OXFORDSHIRE COUNTY COUNCIL'S RESPONSE TO CONSULTATION ON THE FOLLOWING DEVELOPMENT PROPOSAL

Application No: 17/00610/REM-2

Proposal: Reserved Matters to Approval 10/01642/OUT - Access for Camp Road Village Centre Highway Infrastructure Works. The original outline application was accompanied by an Environmental Statement.

Location: Heyford Park Camp Road, Upper Heyford, Bicester.

HEYF-5-232 E

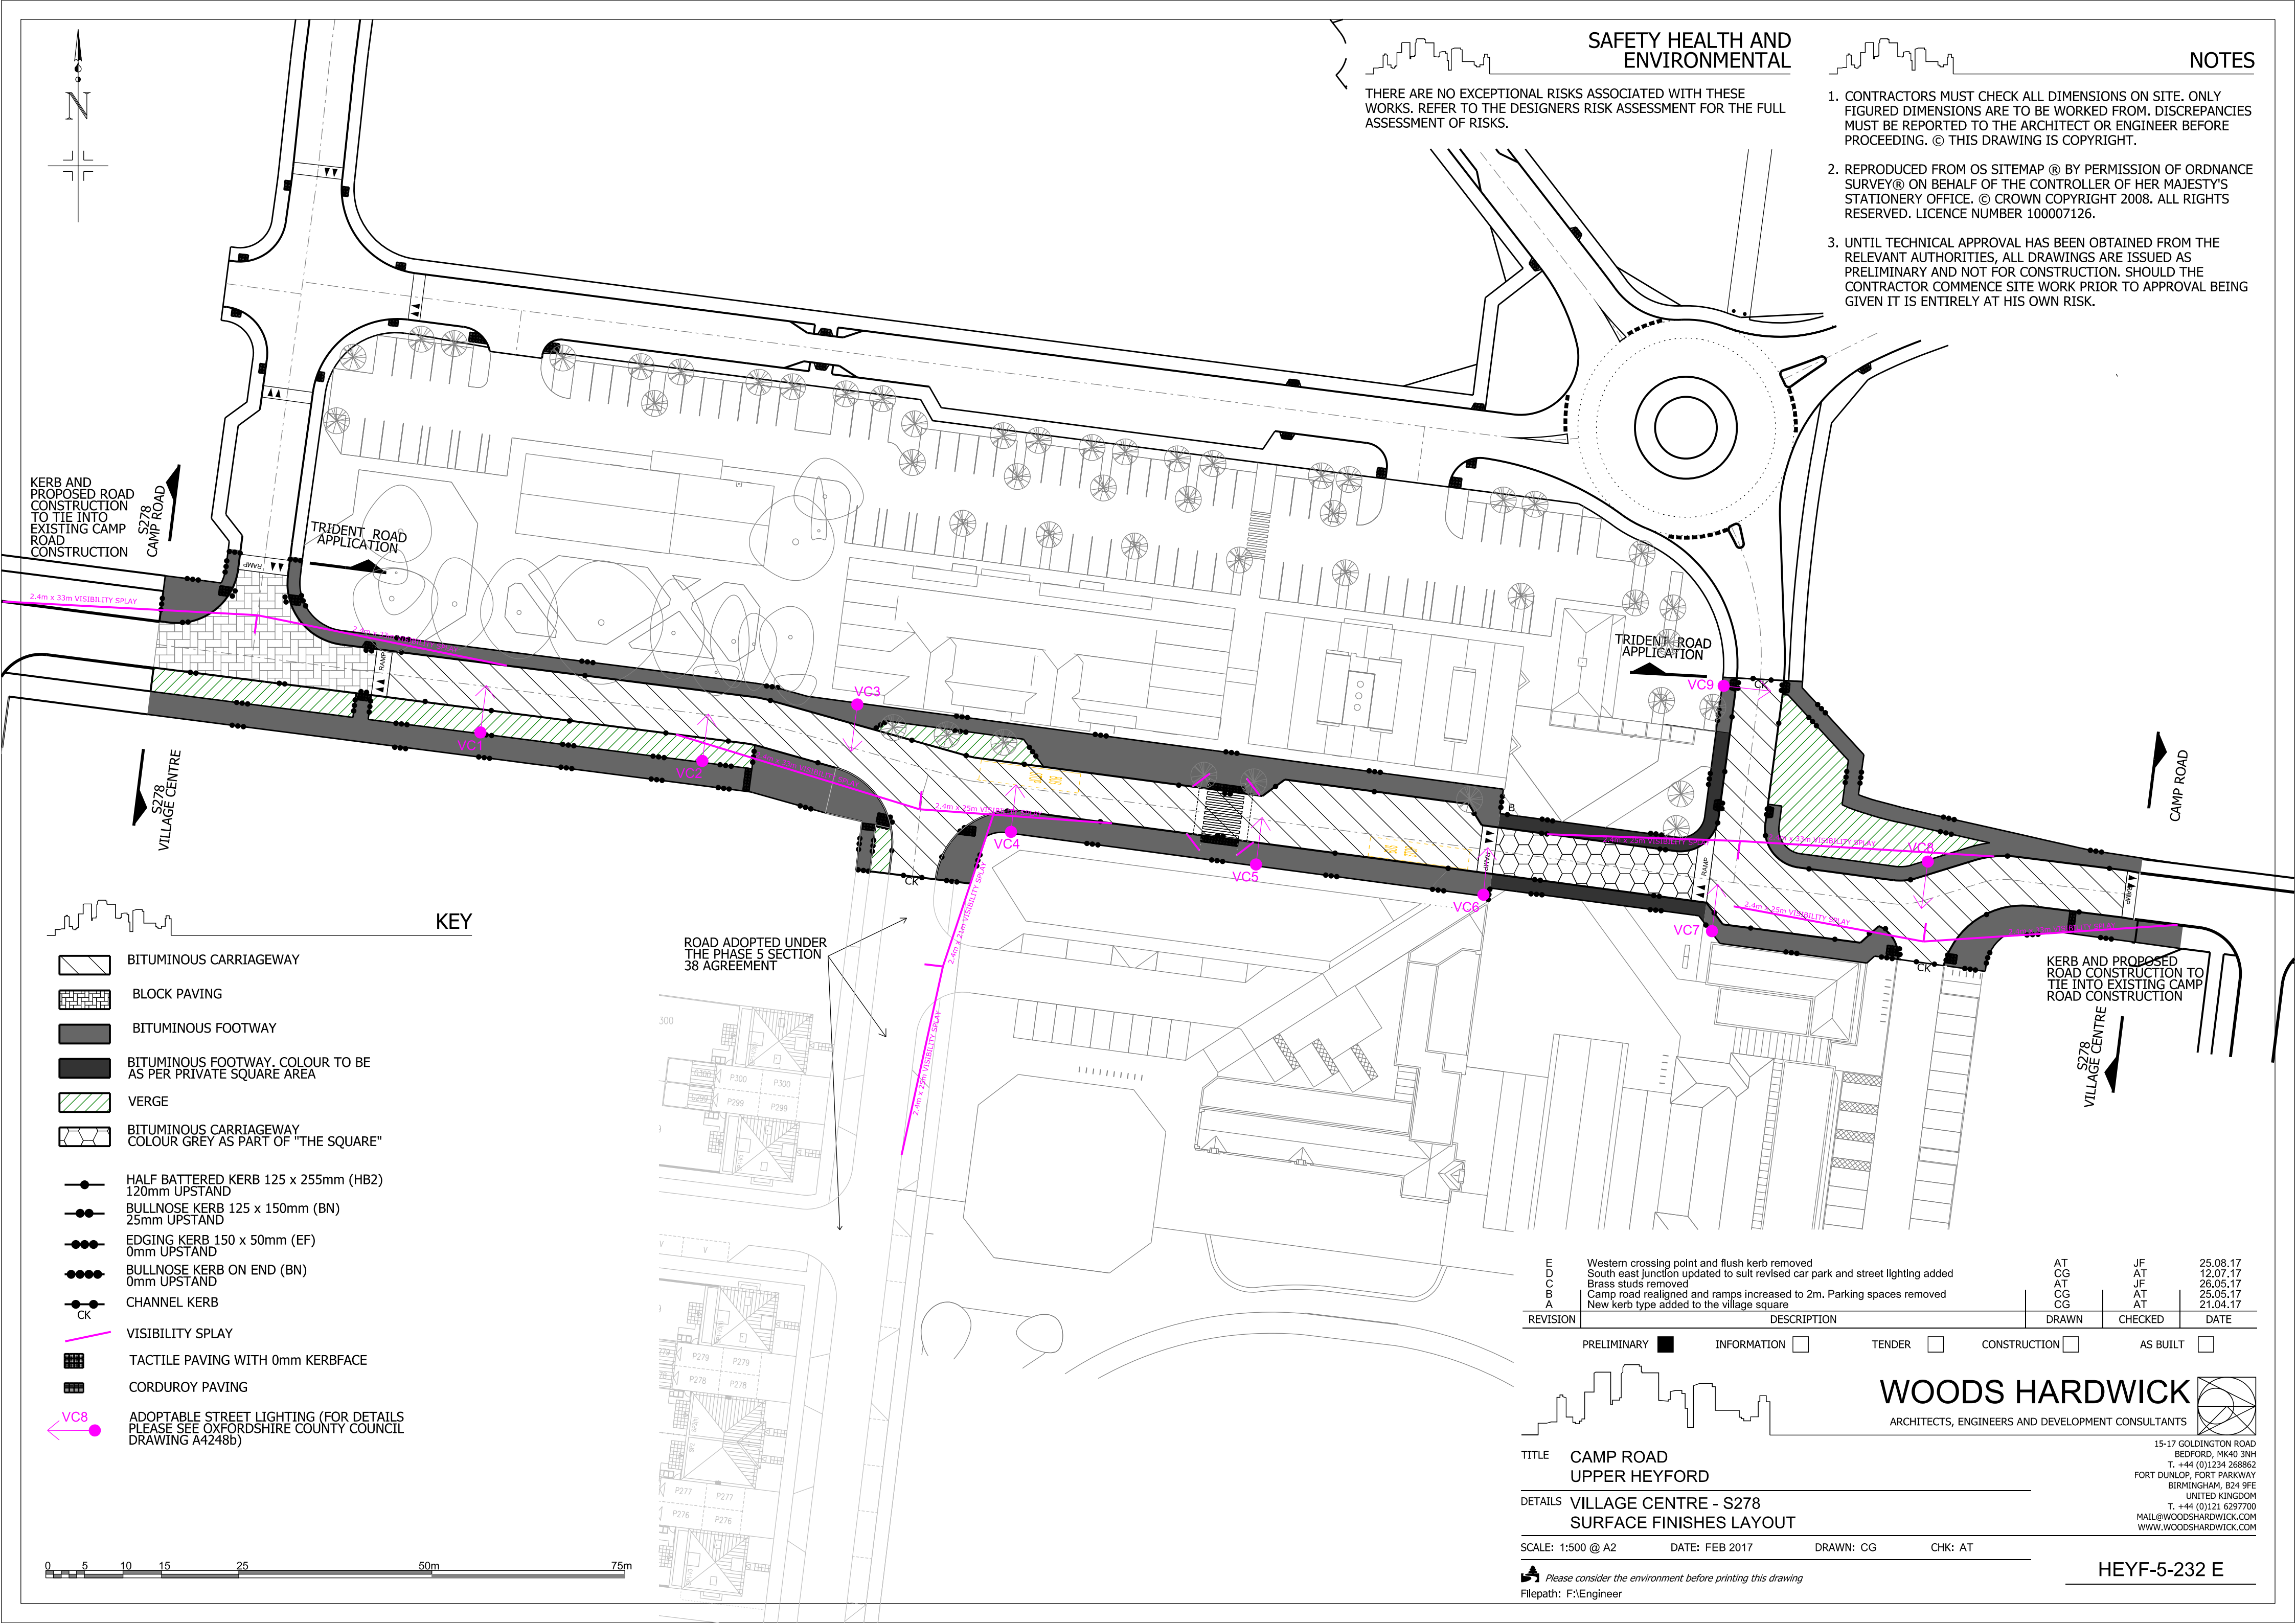
The siting of the bus stops on either side of the proposed zebra crossing, although not against regulations, is still a concern. This applies especially the bus stop on the west side on the approach to the crossing. This should be examined at the road safety audit stage.
